Comments in relation to the following applications by Newett Homes:

2023/92255 Land at Green Acres Close, Emley, Variation of Conditions 1 (Plans) , 2 (Crime Prevention) and 15 (Permitted Development) of Previous reserved matters approval 2021/93286 pursuant to outline permission 2020/91215

2023/92327 Land at Green Acres Close – modified plans for 6 Dwellings plus parking and landscaping and modified plans for ball stop netting.

2023/92255 and 2023/92327 – Plan modifications

Drawing Title	Ball Strike Net		
Site	Wentworth Drive, Emley		
Scale	1:100/1:200 @A2	Date	27/06/23
Drawn	MC		
Drawing No.	2155.110	Rev.	-
Thorpe Arch Grange Walton Road Thorp Arch LS23 7BA 01937 543599 www.newethomes.co.uk

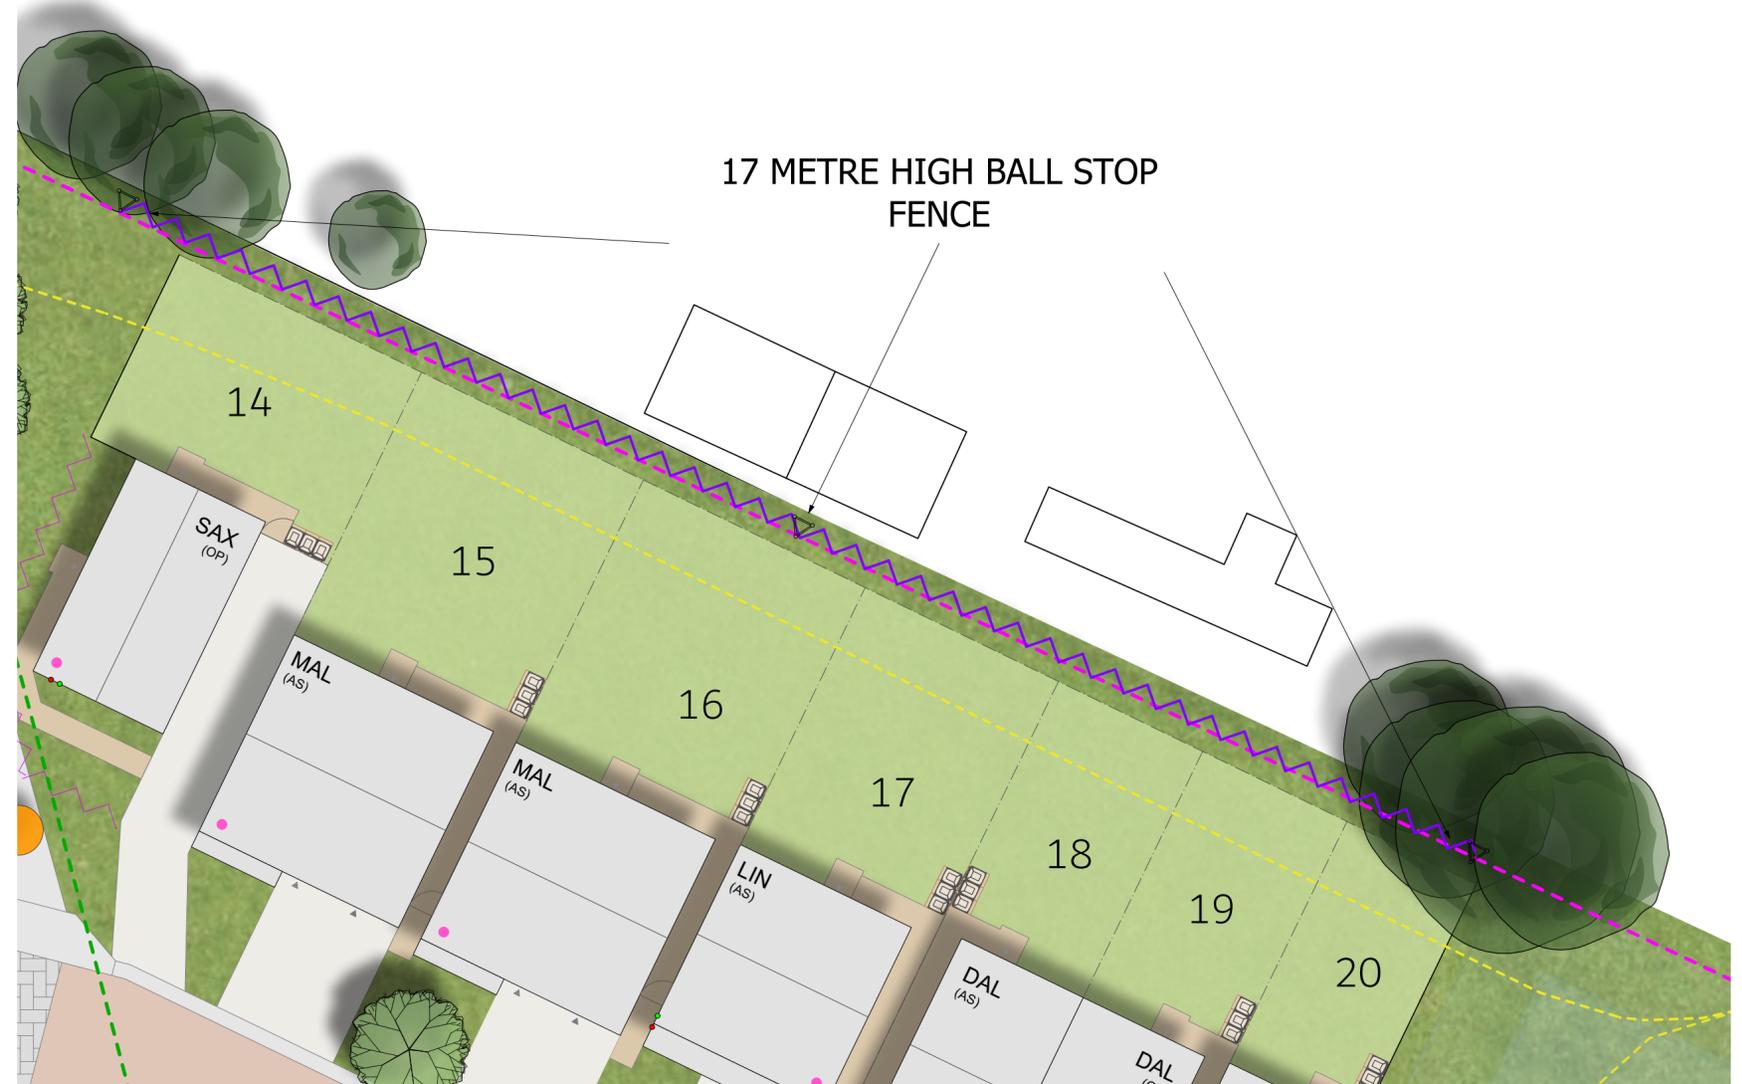
8 – The submitted 'Cricket Pitch Section' plan and the 'Ball Strike Net Plan' both dated 27/06/23 prepared by Newett Homes is not sufficient. There is no information or evidence to show that the stanchions/supports and netting design nor the new position of the net, nor the height of the net is adequate. The cricket field and the development land are exposed to high winds and adverse weather and this needs to be factored into any design. The balls strike netting needs to be robust enough to withstand the extremes of weather experienced in Emley, and to prevent rattling and whistling noises disturbing residents in the vicinity. With no detailed

design developed and engineering solution considered for the ball strike net how can the impact on under mining and or impacts to adjacent trees and impact to foundations and or site levelling be validated, a tree root growth study should be carried out to see if the foundations of the ball strike net impact the structure of the trees.

10 - The proposed netting and its height is not what was approved in the Planning Application 2021/93286. The Labosport LSUK.21-0698 dated 19/11/2021 gave a height of 18 metres but Newett is now using 17 meters. A new Labosport/Newett Boundary Risk A new assessment is required to look at the heights again particularly due to the proposed nets being moved and the claimed PROW now being incorporated into the new design. As already stated, this should be a physical survey by Labosport not a desk top survey, they need to visit the site to appreciate the position and the situation. The report was also only written for recreational cricket something that does not accurately reflect the use of the facility.

11 - The proposed netting is not only lower than it should be, but it does not extend to the perimeters originally proposed. It is shown as not extending the full length of the cricket field wall, ie where the proposed attenuation tanks are to be grassed over and the development children play this area is not covered by the safety of the nets. Are children not as important as the houses. This is of course in addition to the fact that there will need be access for a "cherry picker" machine space for repair / maintenance of the ball stop netting - which would need a clear 3.00 m driveway, and this is not reflected in the most recent proposals to Kirklees. The current site levels (land) also have an impact (it is not flat). Access to maintain the net is critical and has not been considered. The fact that "meadow grass" is identified as the material that a cherry picker drive will drive across will mean an all-terrain version is required. They have out-riggers – probably greater than 3m. The whole design around the nets requires significant and very detailed review as it has limited consideration for the impacts of the most basic aspects of ball strike risk and future management.
